From: Russell Hand <RHand@cityofsydney.nsw.gov.au>
Sent: Thursday, 16 June 2016 3:31 PM
To: Ian Mundy
Cc: Christopher Corradi; Margaret Desgrand
Subject: RE: Section 75W Modification Request to Headland Park and Northern Cove – Main Works, Hickson Road Barangaroo (MP 10_0048 MOD 9) – Trim Ref S076158

I refer to the Barangaroo Delivery Authority's Section 75W modification to the Barangaroo Headland Park approval requesting to delete any reference to a heritage interpretation device relating to the Harbour Control Tower ("the Tower") that would have provided a physical representation of the Tower on-site in the form of a void or 'Occulus' with an inscription or installation (such as public seating) within the 4.9m diameter shaft area of the Tower.

DRAWING TITLE:
DEMOLITION PLAN

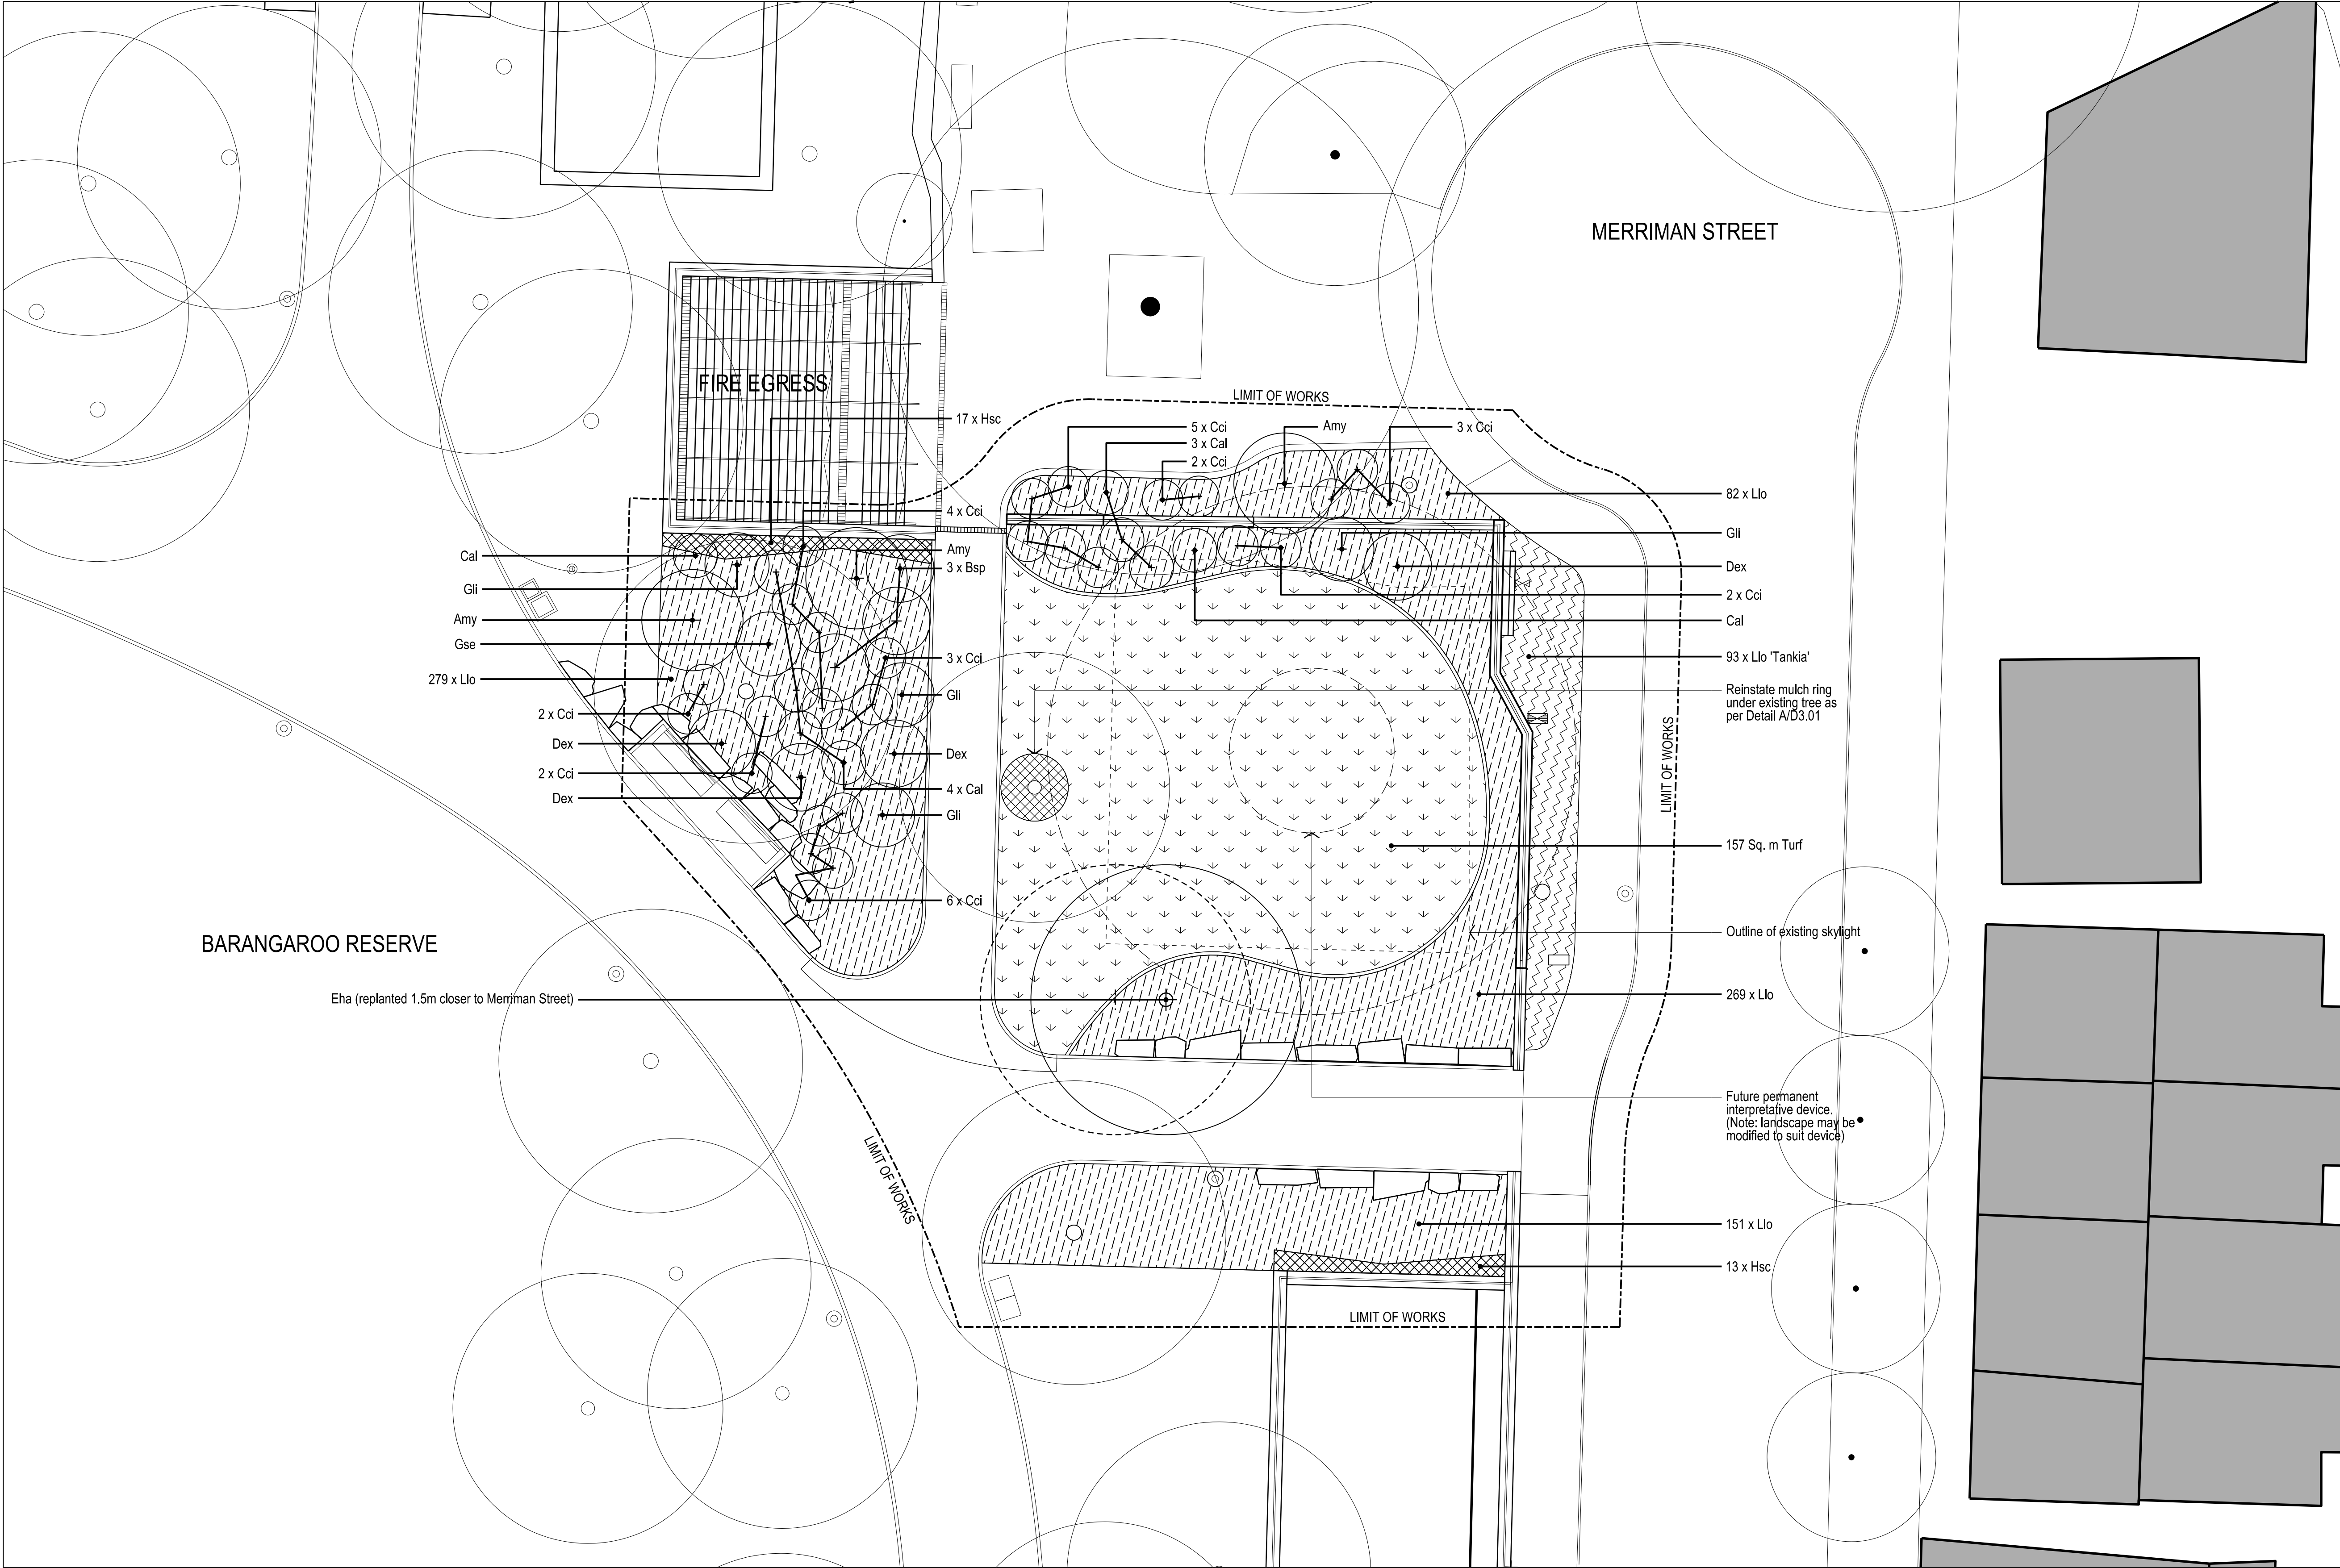
We disagree that interpretation of the Tower on this portion of the site, being the actual location of the structure where it will be appreciated from multiple vantage points, will dominate or overpower any Aboriginal heritage interpretation in the Park itself. The two are readily capable of co-existence with the proper and subtle treatment of the Tower interpretation.

We disagree that any reduction in the size of the existing void around the Tower will create a constraint in terms of existing use for public events and future use as a lettable tenancy in The Cutaway. Public events have been successfully occurring in the cutaway since September 2015 and currently benefit from significant voids already present along Merriman Street for natural light and ventilation. A future tenancy within The Cutaway can function, unconstrained, without a small area (around 36sqm) in one corner of a potential 18,000sqm three-level tenancy.

We contend that interpretation of the structure would be optimised in the actual location of the structure and that the proposed 'Maritime Stories' interpretation along Hickson Road can function alongside the Tower's interpretation in-situ. Reliance on signage mediums, public art mediums or other media elsewhere and relatively disconnected in order to convey the significance of the structure is inferior to on-site physical interpretation. A truer sense of discovery and curiosity would be created when the public are able to immediately relate an interpretation device to the location of the former structure. A lasting reminder of the structure where it stood is significantly more meritorious than a media used hundreds of metres away.

We contend that future opportunities to interpret the footprint of the Tower in any future tenancy fitout DA is inferior to the Merriman Street level interpretation. Such a 'future opportunity' also has no certainty attached to it.
